Engineers Comments Regarding Surface Water Drainage

Application Reference:	LU/98/26/PL	Reviewer Reference:	ADC/EXT5/AF
Planning Officer:	Kathryn Welch	Date of Review:	26/05/2026
Site Name:	16 Swanbourne Road Littlehampton BN17 6HS		
Application Description:	Erection of 1 No single storey dwelling with car parking and provision of driveway and car parking for No. 16 Swanbourne Road (resubmission following LU/96/25/PL). This application is in CIL Zone 4 and is CIL Liable as a new dwelling.		
Assessment Number:	1

Key  - BOREHOLE	Drawn	CB		Client: CGS CIVILS LTD		
	Approved	JO		Project: GROUNDWATER MONITORING WELL INSTALLATION 16 SWANBOURNE ROAD, LITTLEHAMPTON		
	Date	19/11/2025				
	Scale	NTS		Title: INVESTIGATION LOCATION PLAN		
	Original	A3		Project no: NN2075	Figure no: FIGURE 1	Rev: 1

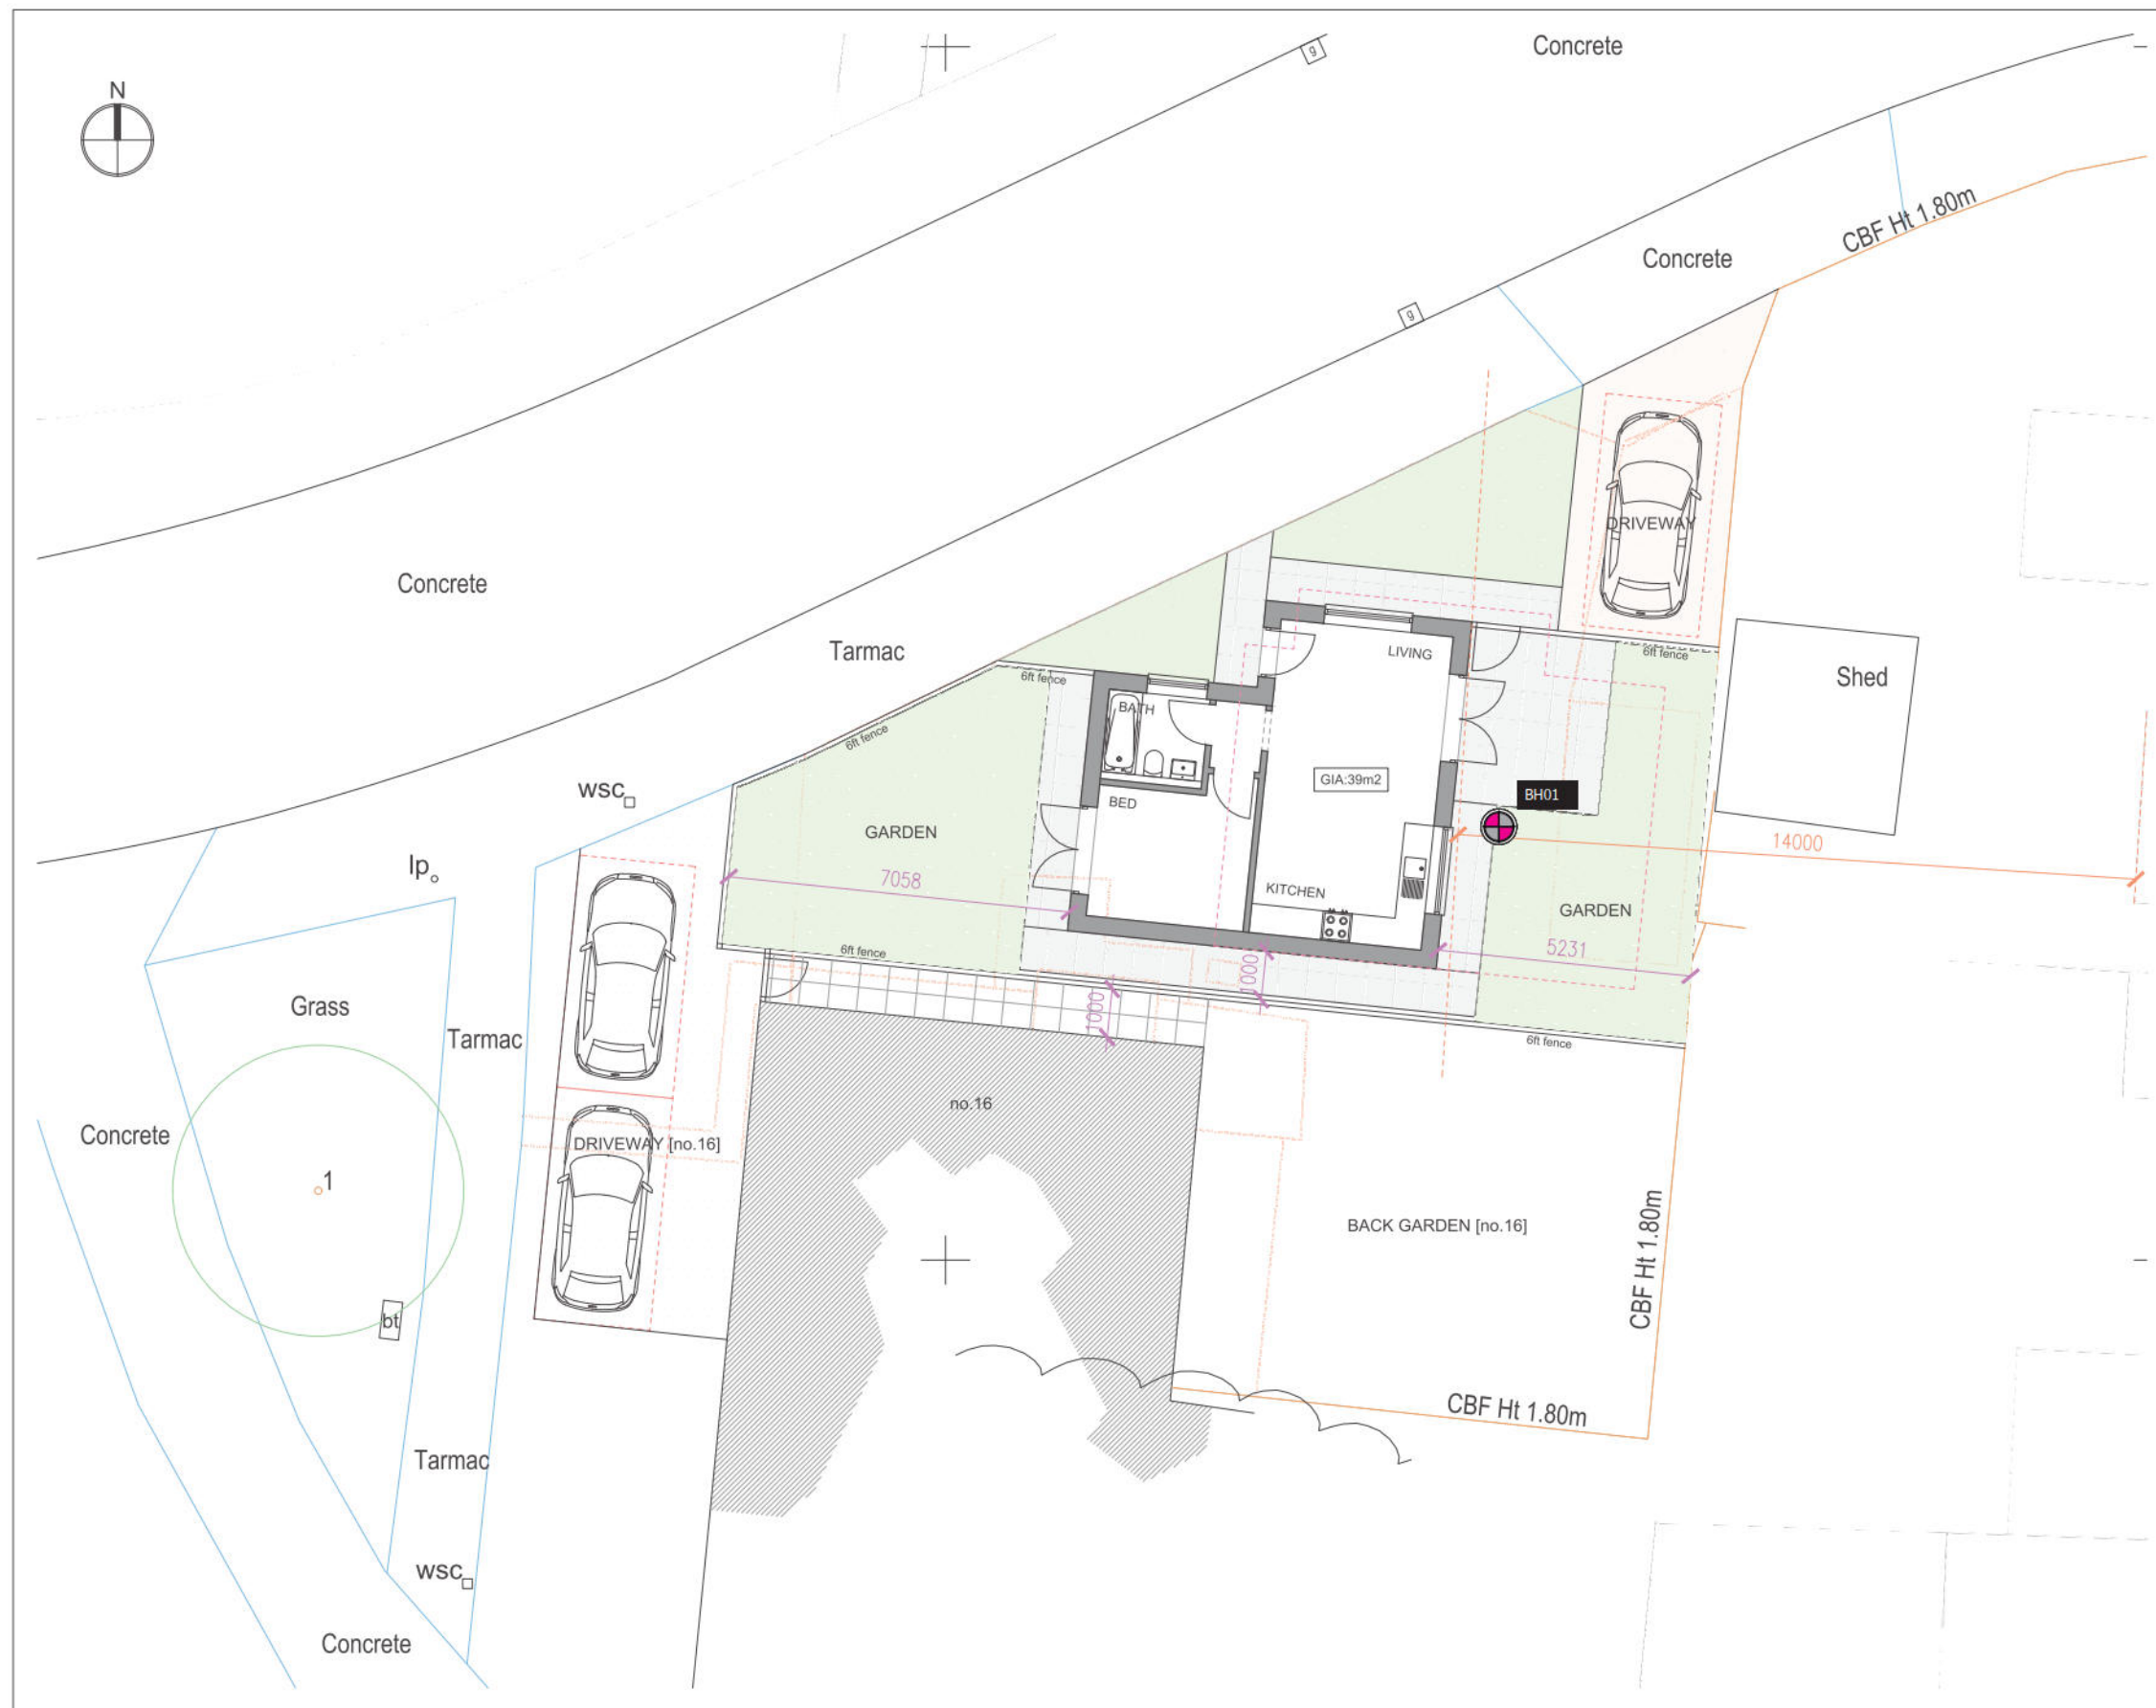
- 1.4. The groundwater monitoring measurements are every two weeks and therefore do not accord with the ADC ground investigation checklist requirements. However, the results are sufficiently robust to demonstrate groundwater levels are comfortably below the 1m vertical buffer from the proposed base of soakaways.

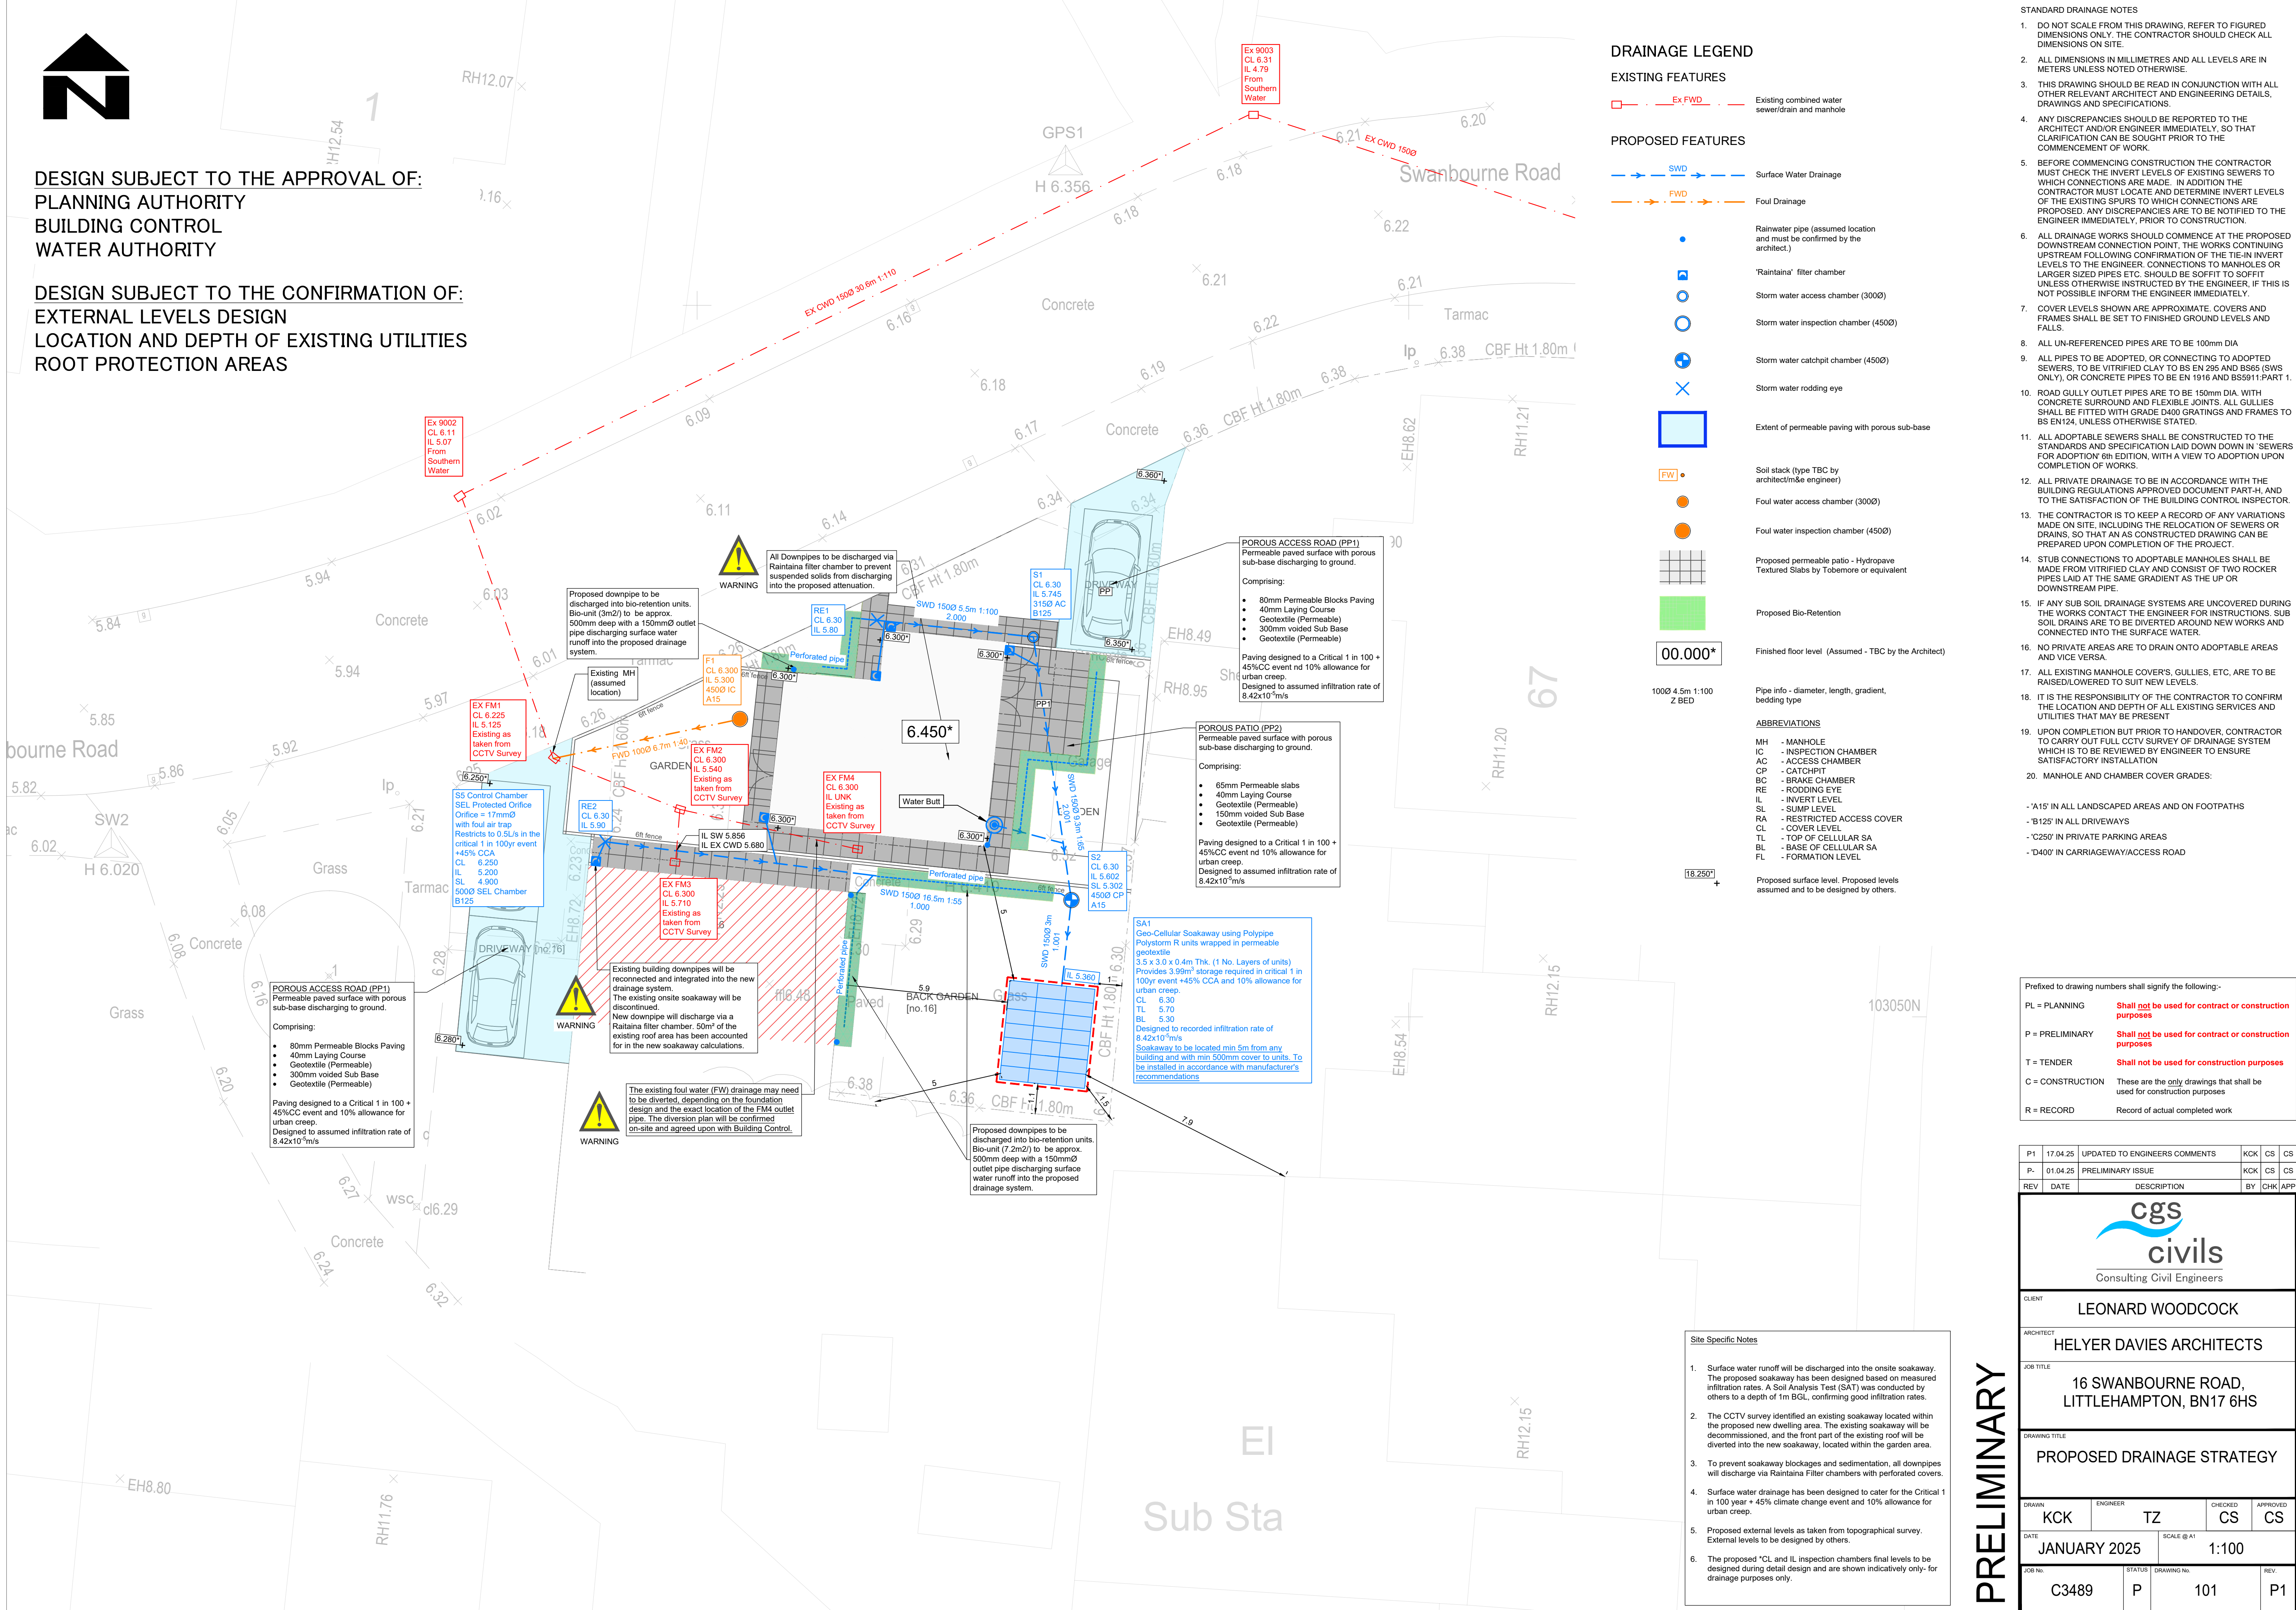
- 1.1. Water butts are shown and are suitable for small scale residential garden irrigation.
- 1.2. The proposed runoff destination is now solely discharge to ground via infiltration although a flow control chamber is still shown on the drainage layout and in the calculations but it appears to be redundant and not part of the drainage design.

- 3.1. Calculations are provided for the design storm and show no flooding. Drained area and modelling parameters are acceptable.
- 3.2. There is a flow control chamber, S5, including on the layout and in the calculations which appears to be orphaned/redundant and should be removed for clarity.
